**From:**  
**Sent:** 14 January 2024 20:12  
**To:** DCAdmin  
**Subject:** Planning application 2023/93468

Application number 2023/93468

Proposed demolition of existing garage and erection of replacement garage and two storey side extension with loft conversion.

Project Name and Address :
14 LADYROYD DRIVE
BD4 6RP
(TWO STOREY SIDE EXTENSION)
Client :
PAUL
Title :
PROPOSED ELEVATIONS

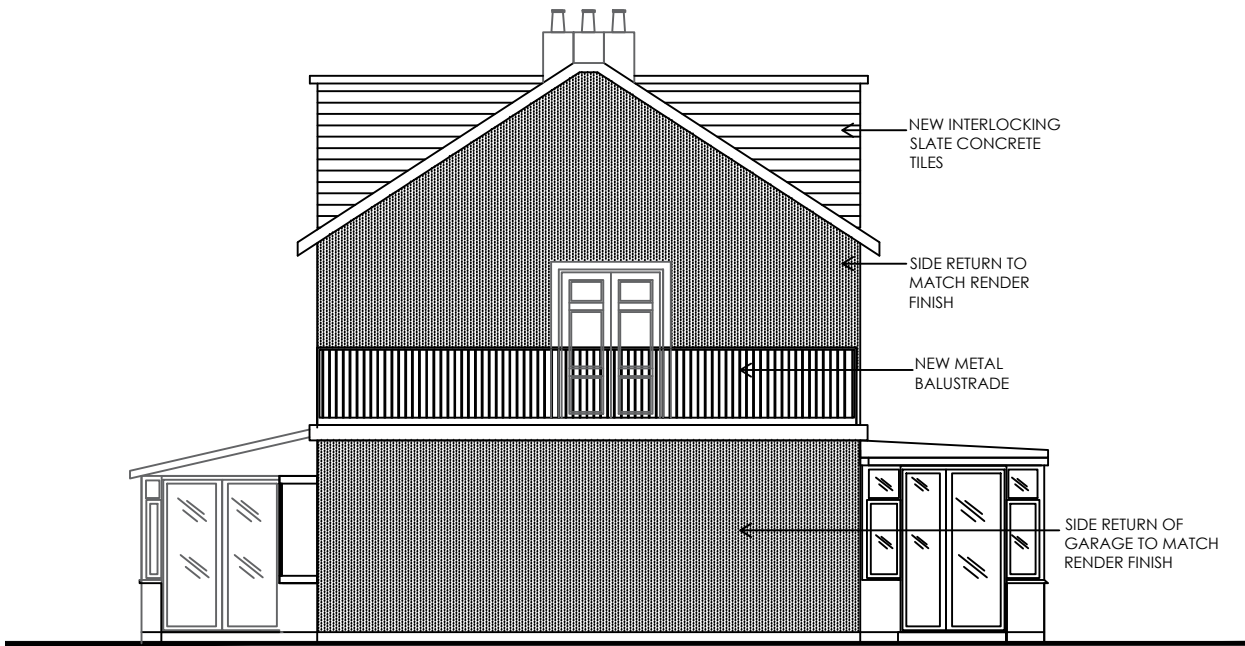
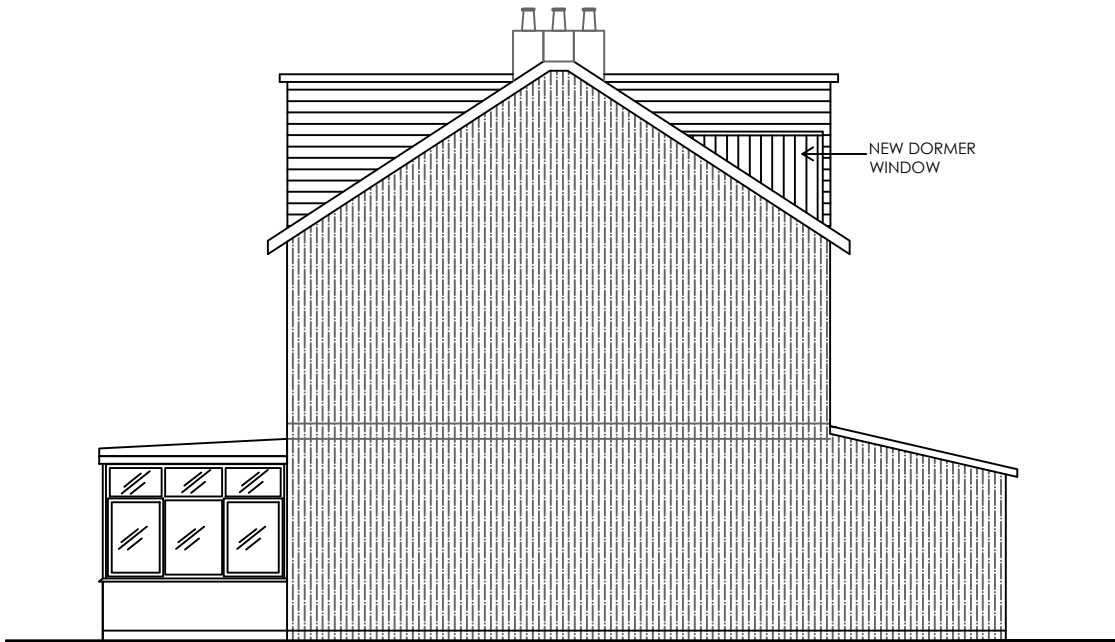
1. Layout and density of the building.
2. The proposed extension floor plan will exceed the current existing property floor plan and will be overbearing.
3. Invasion of privacy due to the proposed close proximity of the elevated garage roof top terrace, which will allow an unobstructed, elevated, direct view into our lounge dining area, patio and garden room.
4. Invasion of privacy from the proposed side elevation double patio doors, which will allow an unobstructed, elevated, direct view into the afore mentioned areas of our property.
